Oulton Parish Council (OPC) have recently sent in comments in regard to the **‘Response to Secretary of State Letter dated 9 July 2021 - Updated information on cumulative and in combination effects with the Dudgeon and Sheringham Shoal Extension Projects’** this was sent on 10th September 2021 and accepted on the 23rd September.

OPC would therefore like the opportunity to highlight some further issues from the **cumulative impact** document.....

Co-ordinate system: British National Grid EPSG: 27700

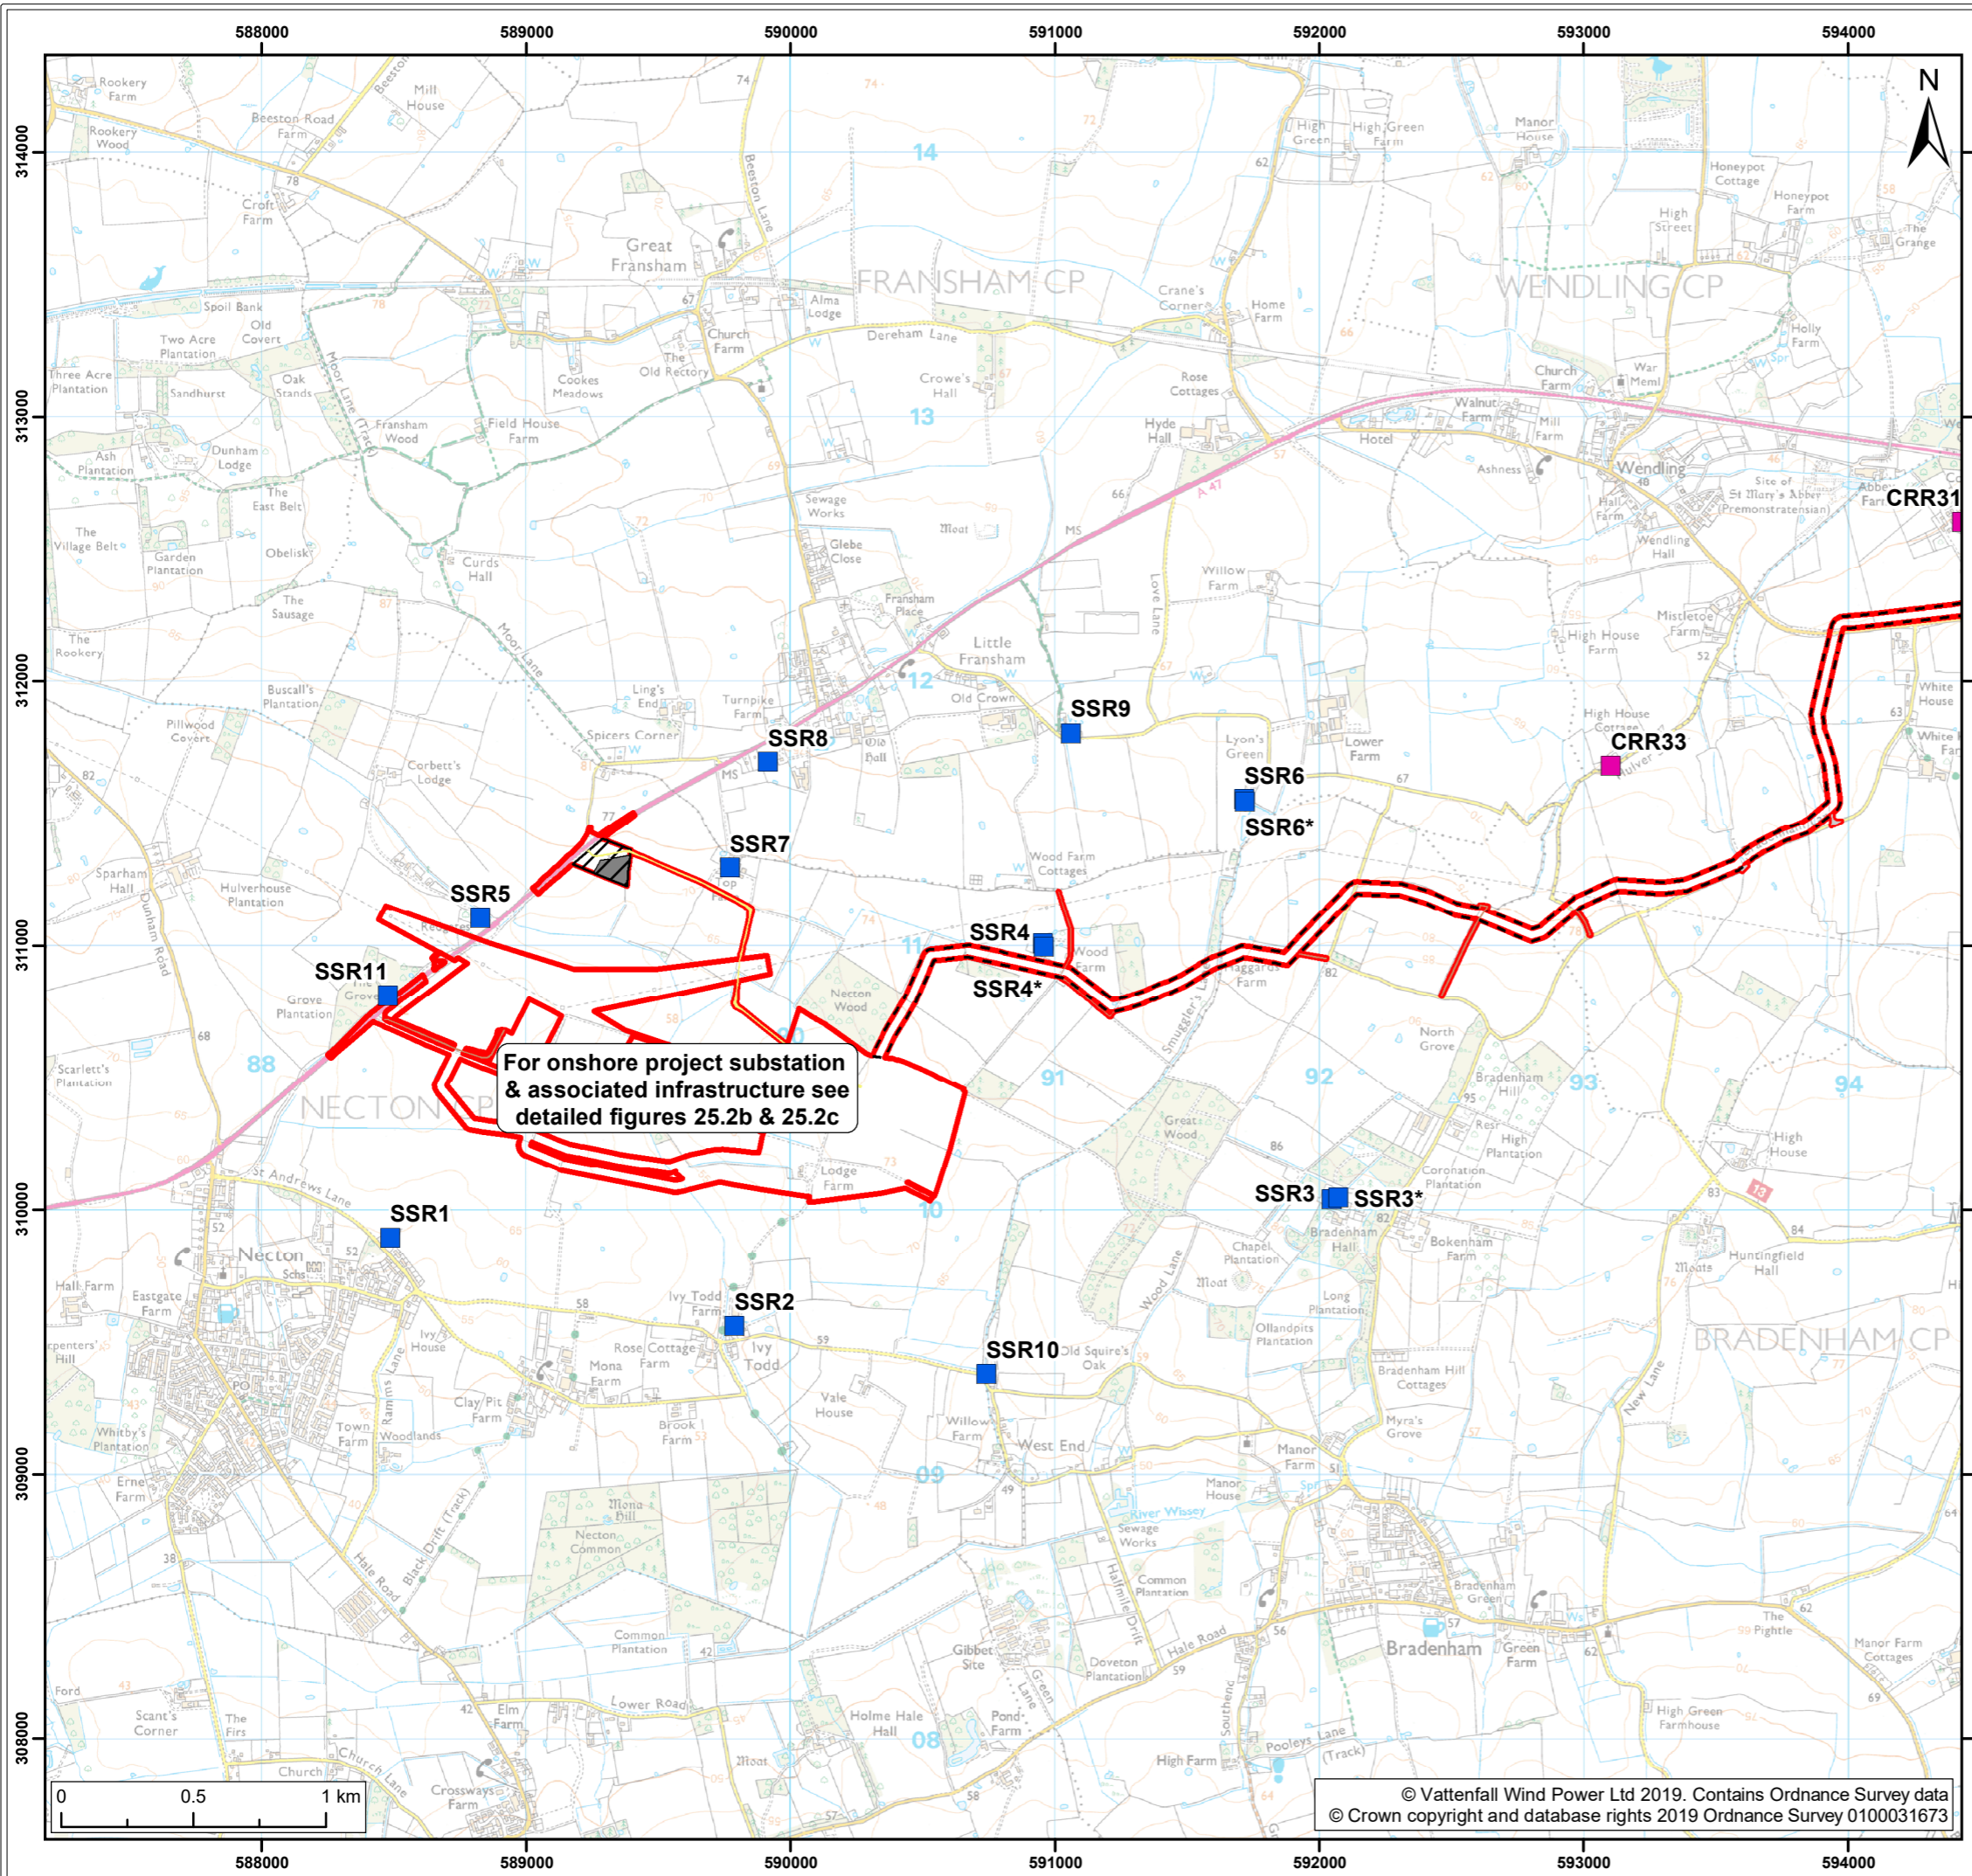
The proposed DEP and SEP onshore cable route would cross the Norfolk Boreas cable route east of Cawston. There is a common noise sensitive receptor in proximity to both projects (CRR12 as shown on Figure 25.2 of ES chapter 25 Noise and Vibration [APP-470]). Construction noise at CRR12 for Norfolk Boreas was assessed as no impact during the peak construction phase (2023/2024). The DEP and SEP cumulative impact assessment concluded that there would be no cumulative construction noise impacts with Norfolk Boreas.

It should be noted that there will be additional noise at this **sensitive receptor (CRR12)** as there will be the need for a HDD crossing of the B1149 at this point, for Norfolk Boreas Scenario 2. This has been excluded from the cumulative impact. This would also apply to DEP/SEP.
